# CITY OF ALBUQUERQUE

**Re: McMahon Shopping Center**  
**10550 Unser Blvd NW**  
**Traffic Circulation Layout**  
Architect's Stamp 07-20-2021 (A11-D017B)

Based upon the information provided in your submittal received 11-24-2021, the above referenced plan cannot be approved for Building Permit until the following comments are addressed:

UNSER CROSSING
ENLARGED SITE PLAN
10550 UNSER BLVD NW
ALBUQUERQUE, NM 87114
PROJECT #2063

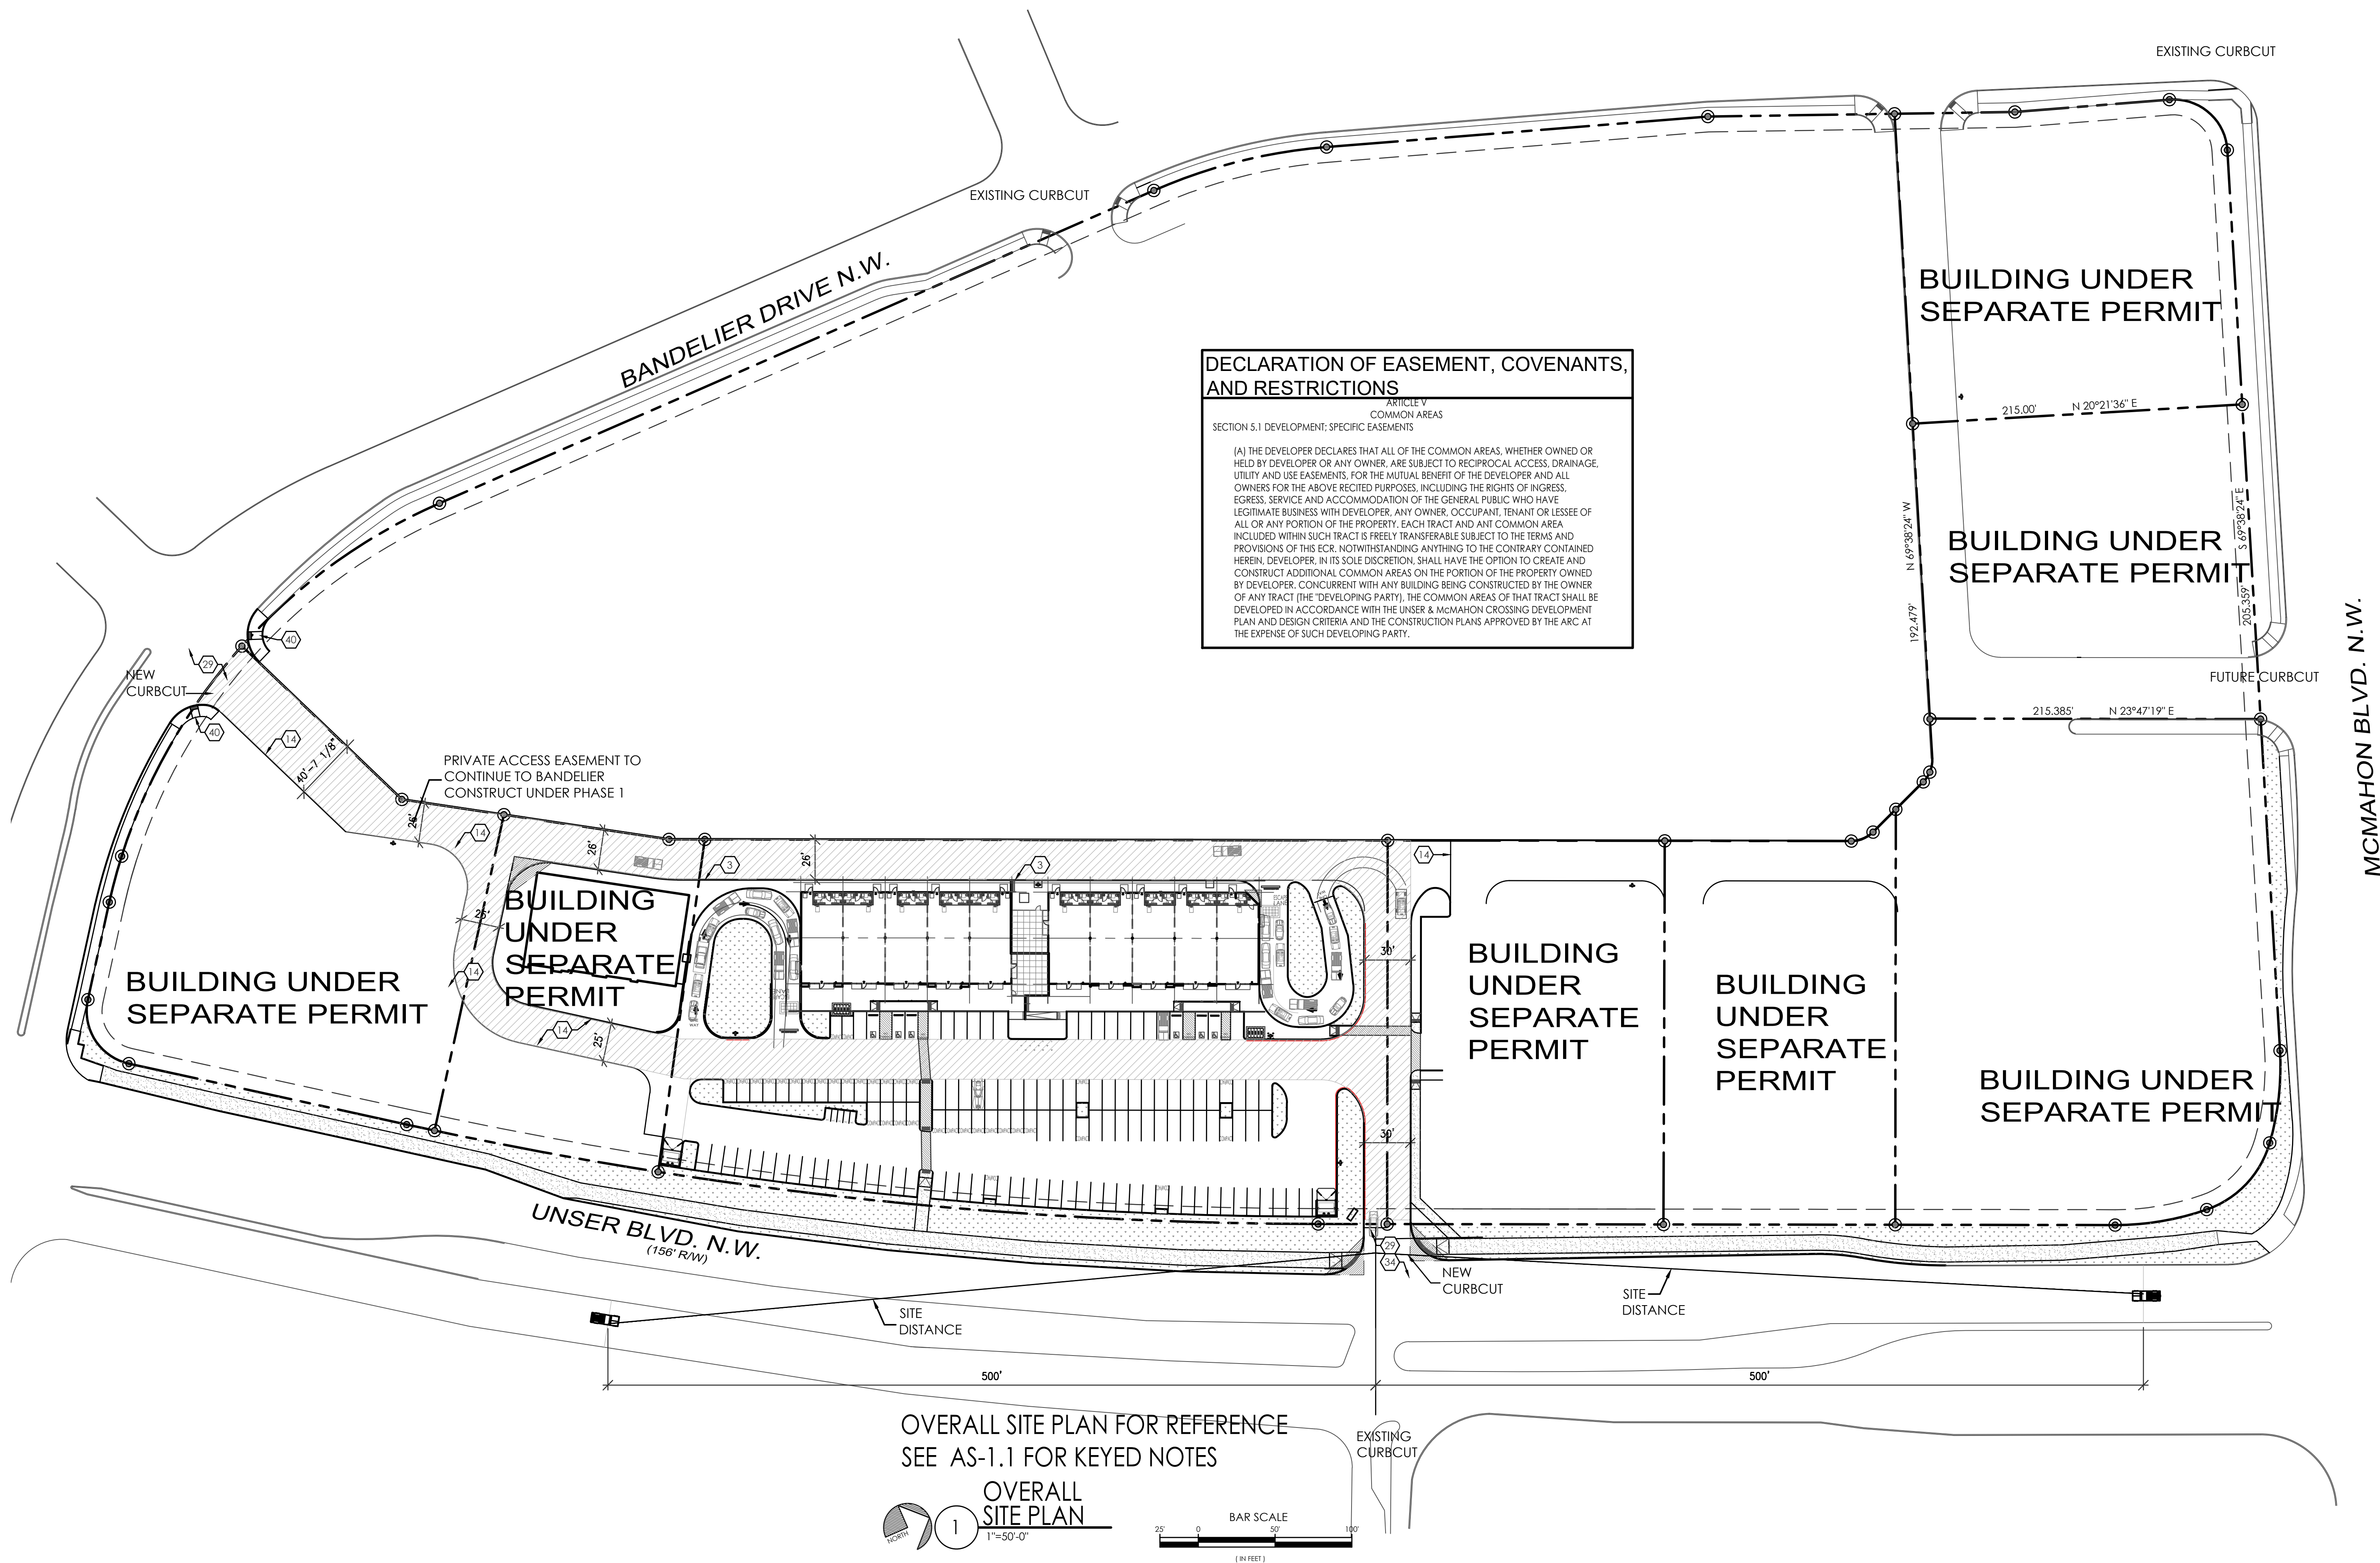
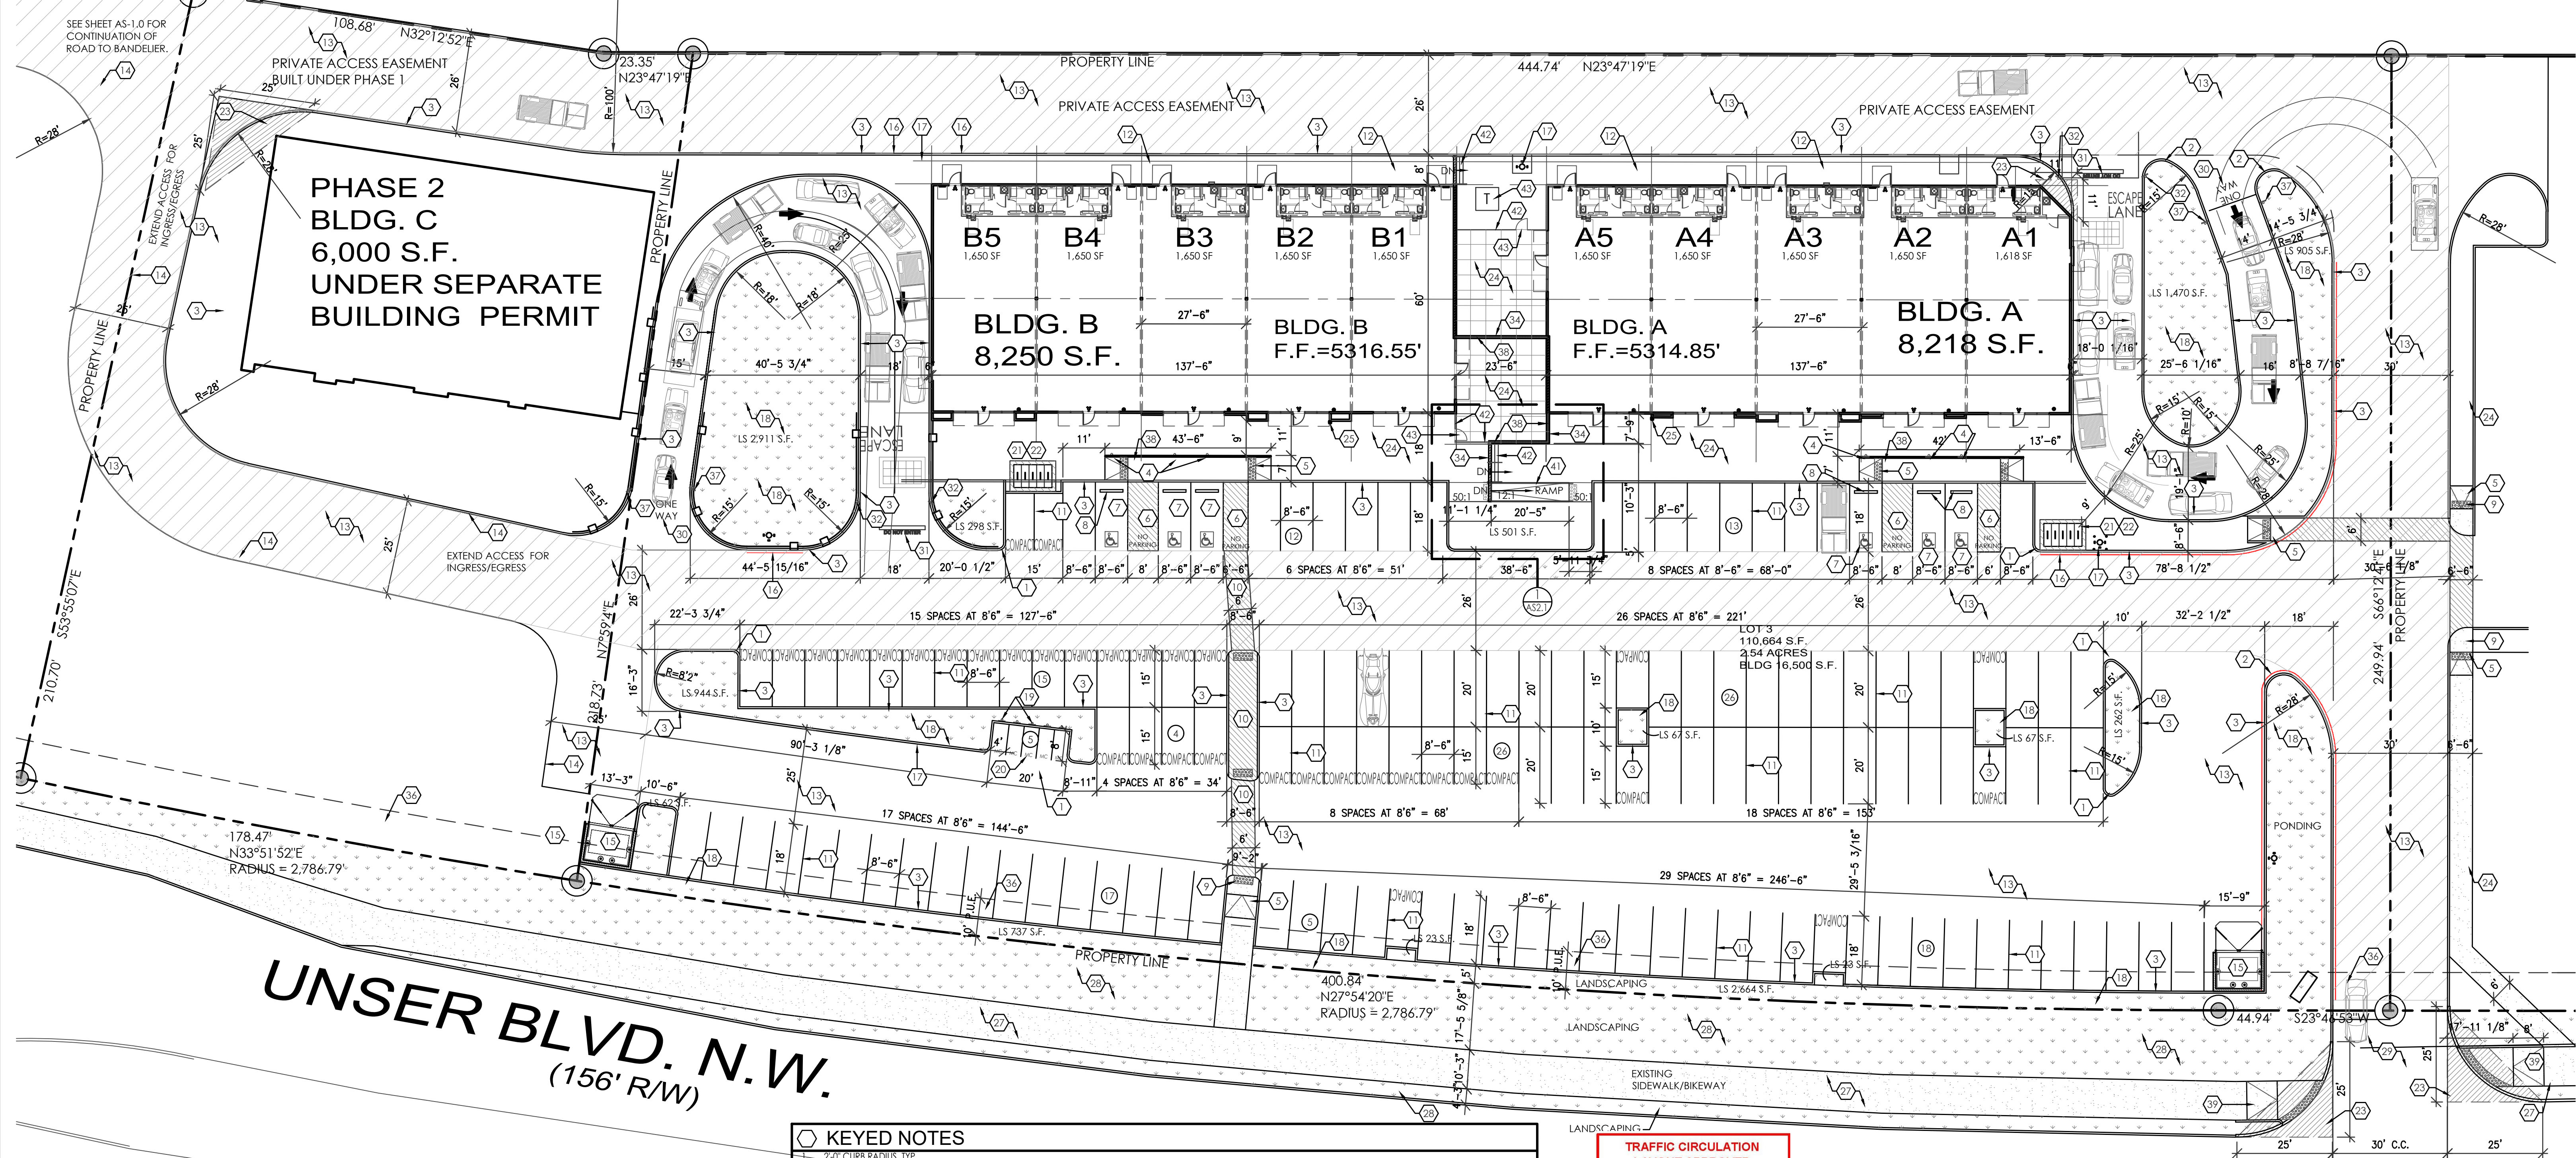
- Provide/show on plans for pathway from Bandelier to Lot 4.
- Bandelier driveway entrance design will need to be shown and construction notes provide to build entrance drive and access road to Lot 4

- The proposed 6 ft pedestrian pathway and ramps will need details/construction notes.
- Note to include details for curbing, striping and sidewalk limits.
- Provide keyed note 27 at Unser frontage trail.

- Provide keyed note 37 at drive thru entrance
- Bike Infrastructure location might interfere with 6 ft pedestrian pathway. Please provide width between keyed note 16 and drive thru to determine if the pathway is reduced/compromised.

- Keyed Note 4: the placement of signage will reduced the required 6 ft ADA pathway. Please address.
6. AS2.0:
- Detail A4: Pathway must be 6ft width inside to inside curb and ramp label 12:1 max.
  - Detail A6:
    - 1. Ramp must be 12:1 max.(label).
    - 2. Landing: 6'x'6 with 50:1 max.(label)
7. AS-2.1:
- Ramp slope 12:1 max call out.
  - Landing (6'x6') slope 50:1 call out.
  - Proposed 6ft width pathway must be inside to inside curb 6 ft in width.
8. Unser Proposed median work and deceleration and Bandelier roadway improvements:
- **APPROVAL OF FINAL CO (A condition for CO) that work order for these roadway improvements be completed, and accepted by the COA.**
9. Please provide a letter of response for all comments given.
